Re: MODIFICATION TO KINGS FOREST APPROVAL NO. 08_0194 (MOD4)

Please find below my submission re the proposed Modification to the Proposed Development at Kings Forest. I believe that the proposed modification should be rejected.

MODIFICATION TO KINGS FOREST APPROVAL NO. 08_0194 (MOD4)

**FIGURE 17**

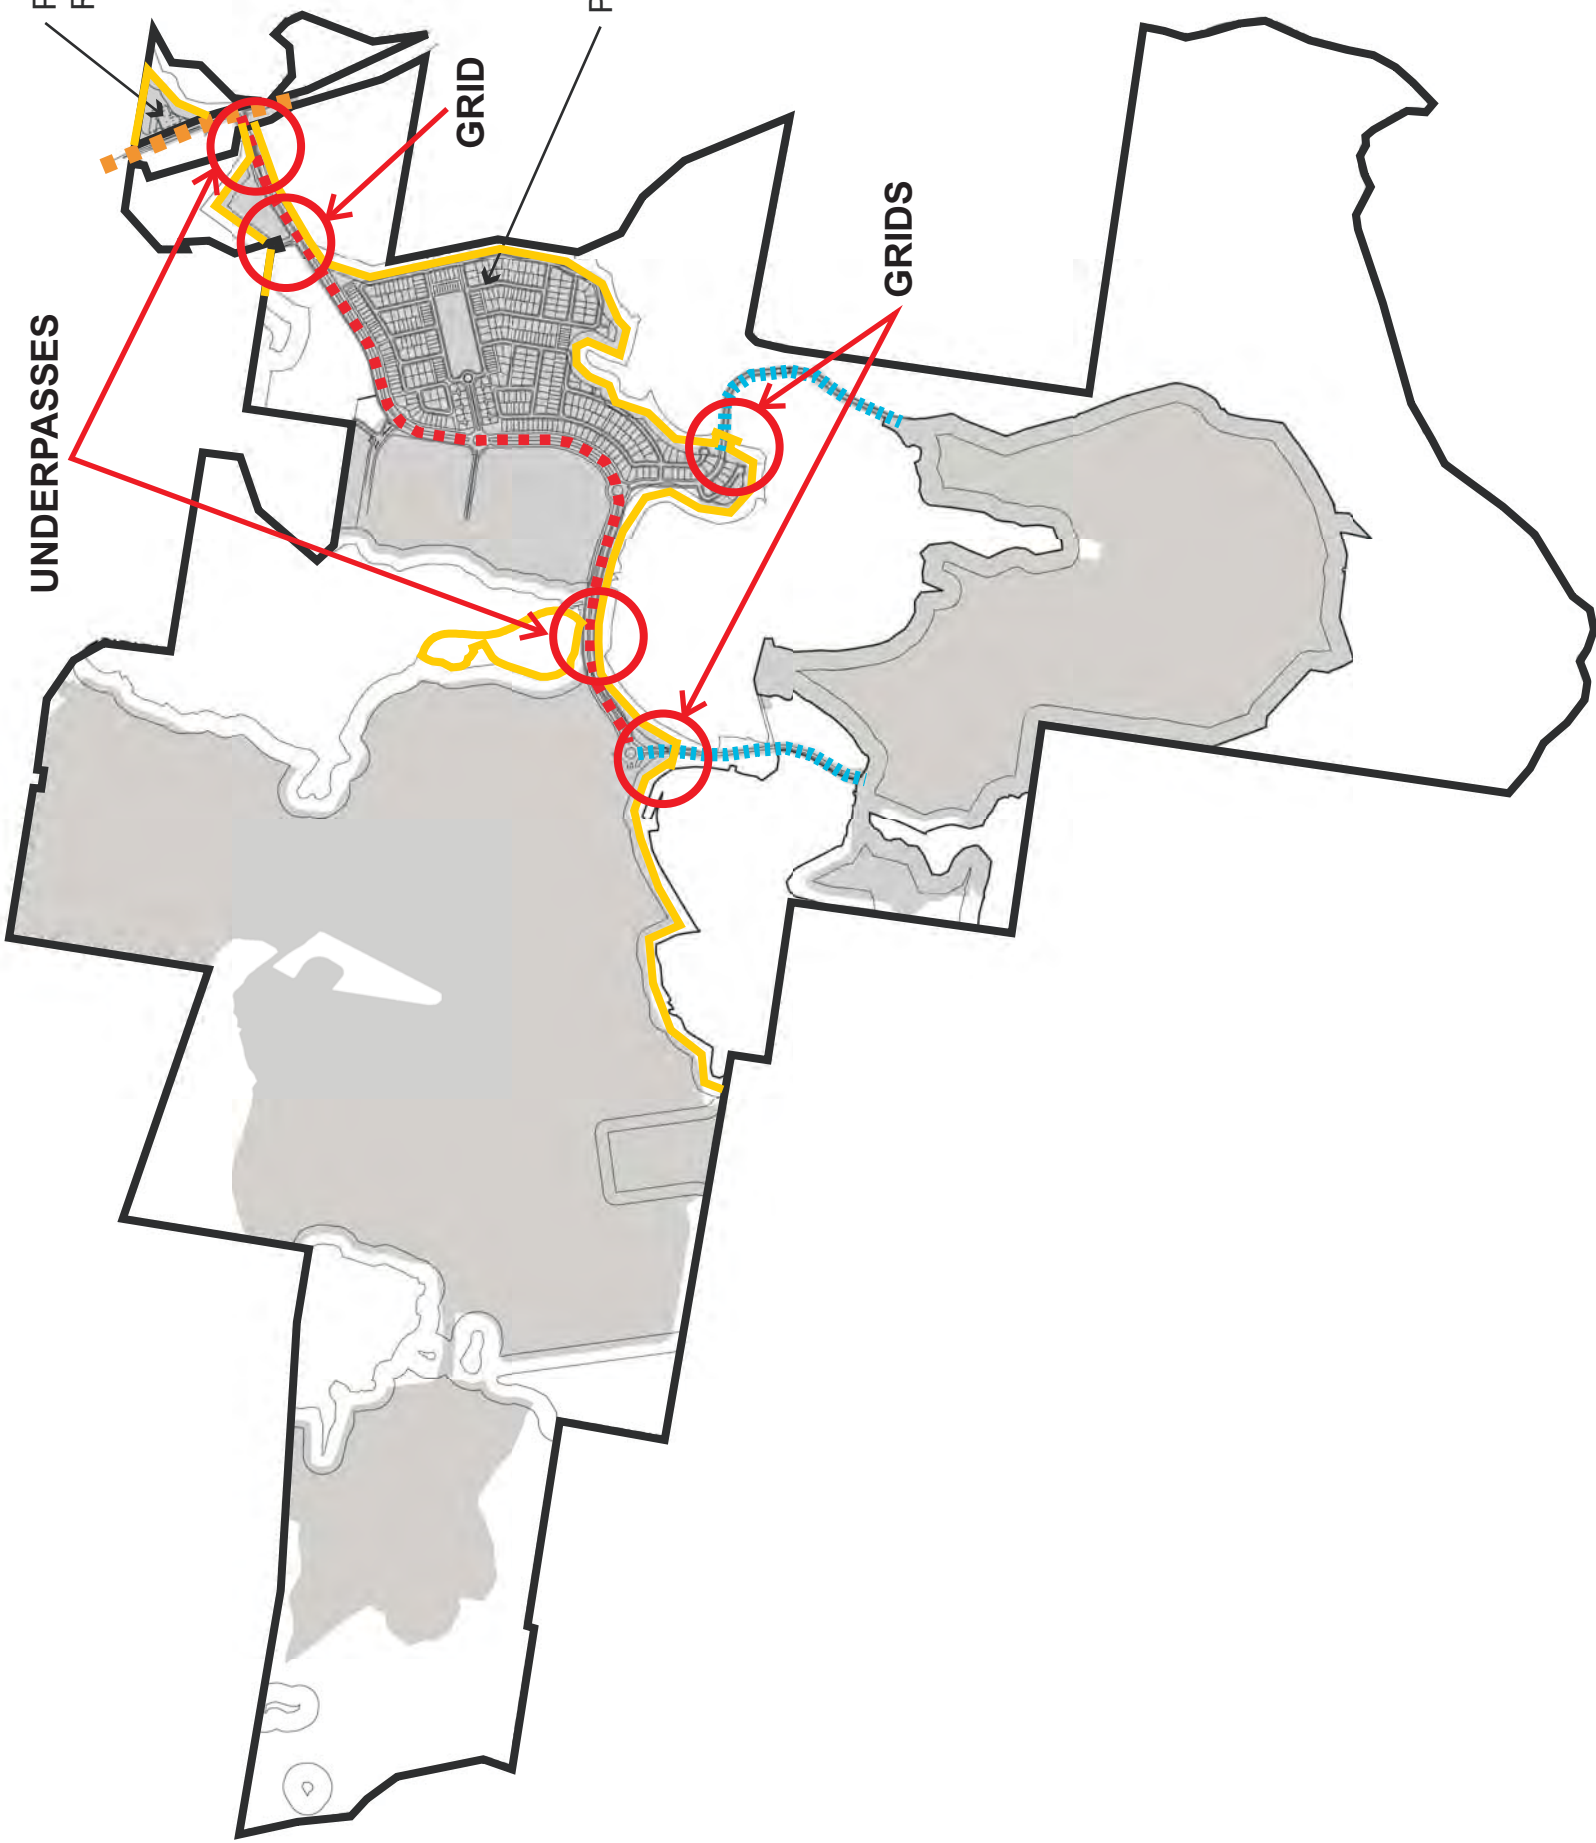
- *They ask to: Delete reference to roads “requiring fencing on both sides” and merely refer to “fencing”*

If this change is approved Koalas will be in direct contact with roads. This is not a plan to manage Koalas, rather it places roads in direct intersection with Koala corridors, with no fencing or underpasses. Cattle grids will not separate dogs from Koala area and from the Nature Reserve in particular.

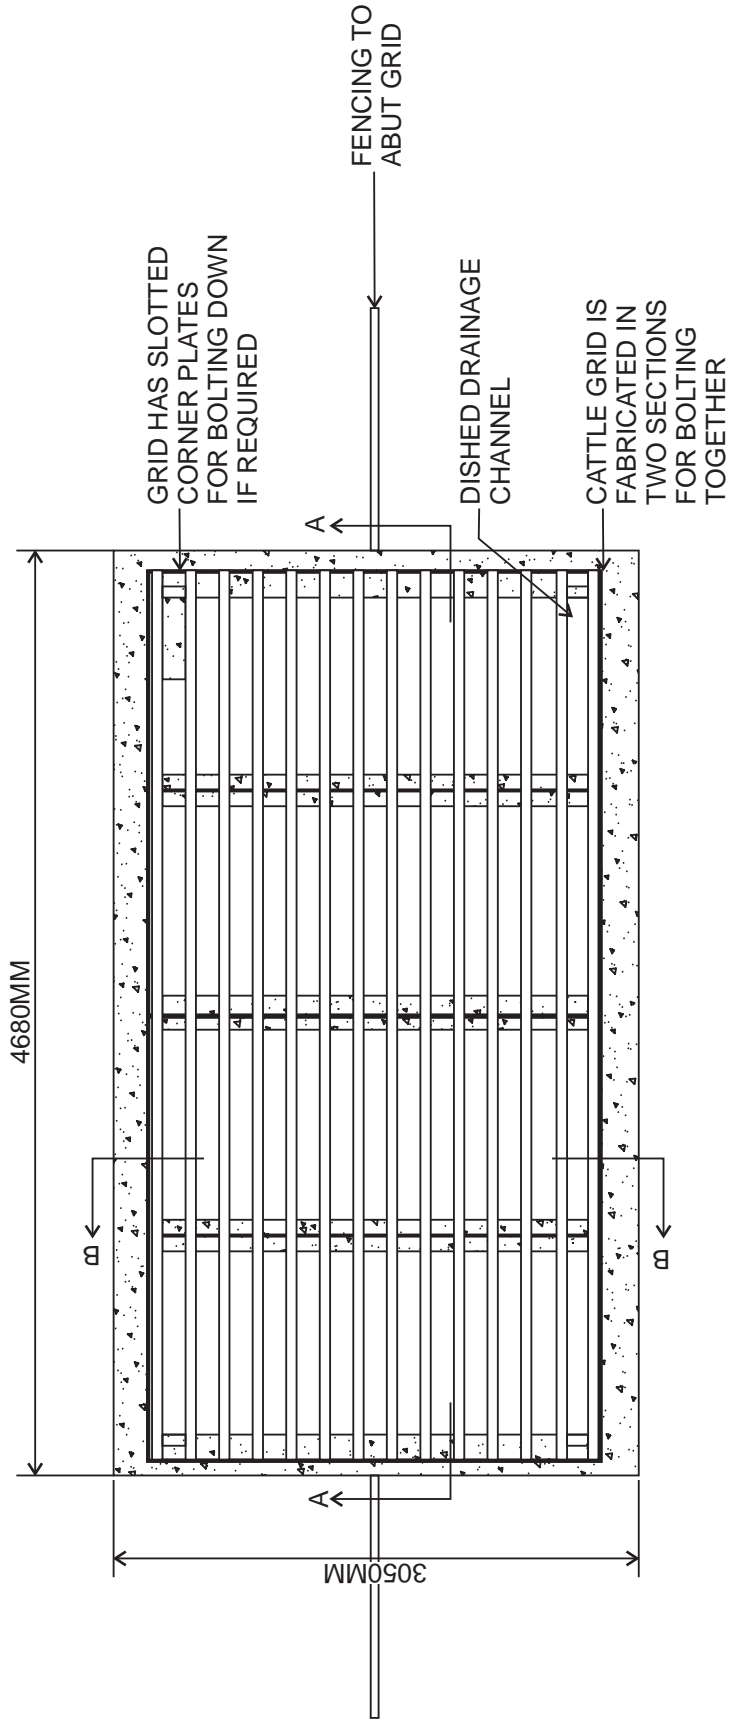
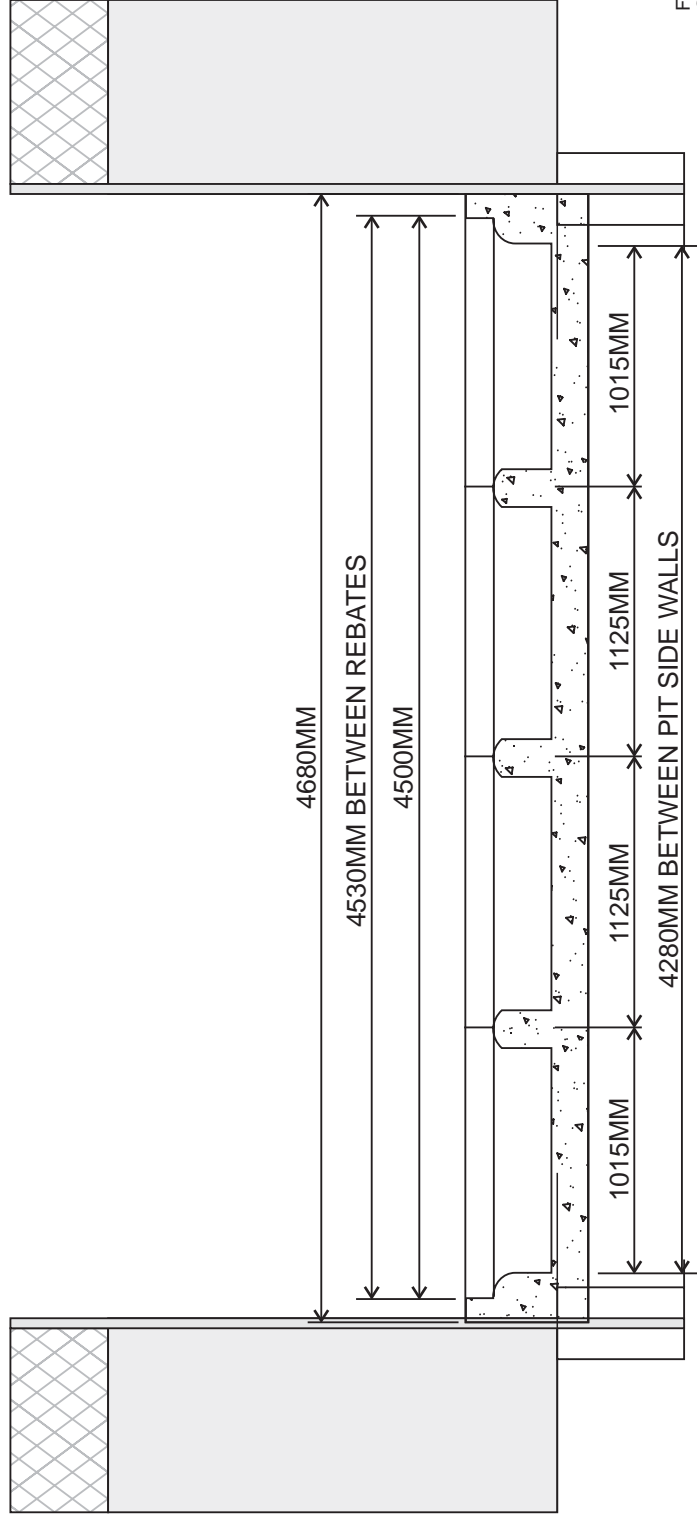
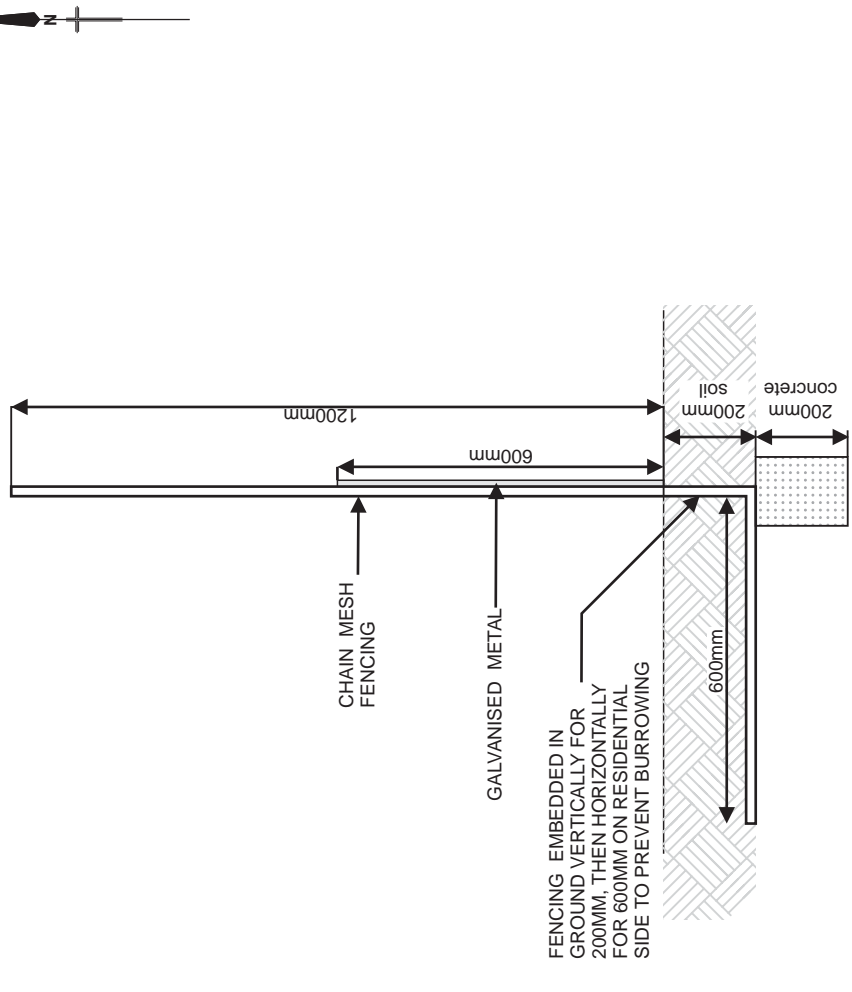
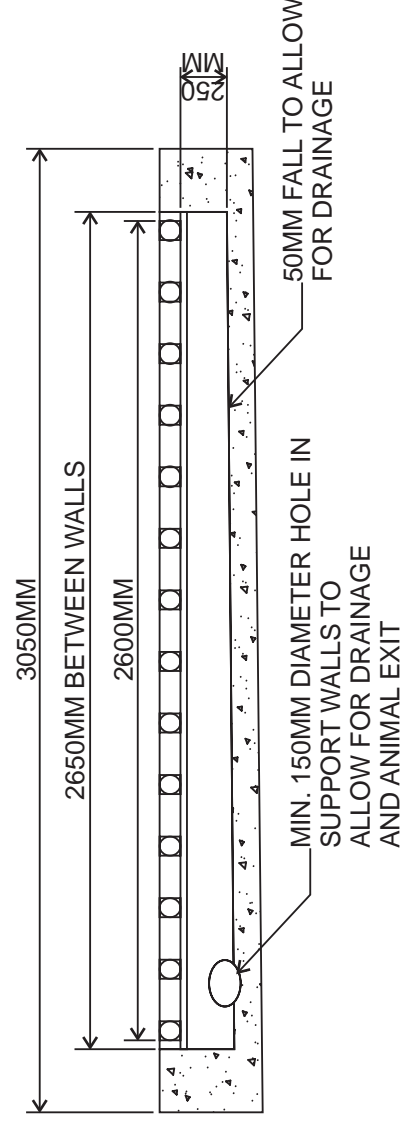
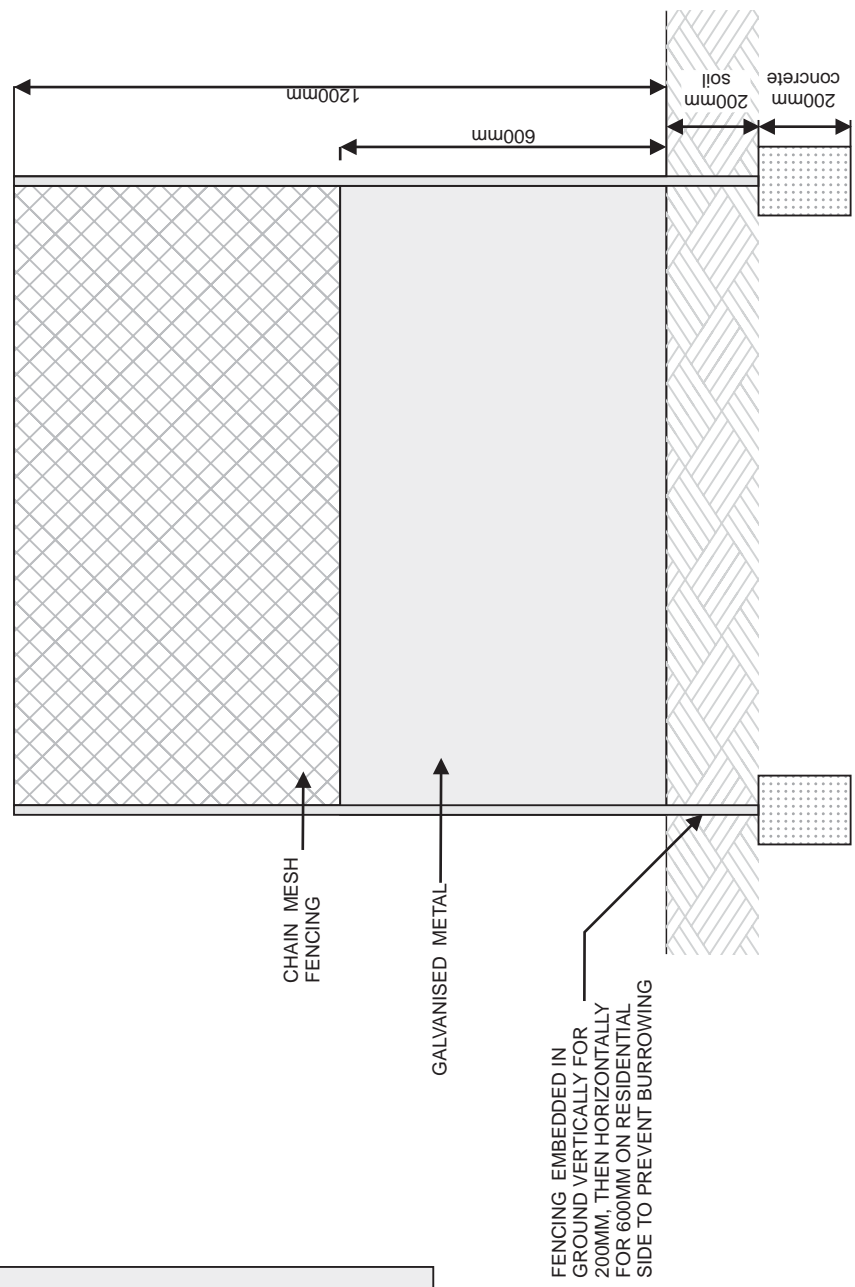
- They seek to change the reference to fauna underpasses “installed at sufficient intervals to allow unimpeded movement by ...koalas across roads” by removing the reference to “across roads”
- Also, they suggest that in some locations to use cattle grids instead of fauna underpasses
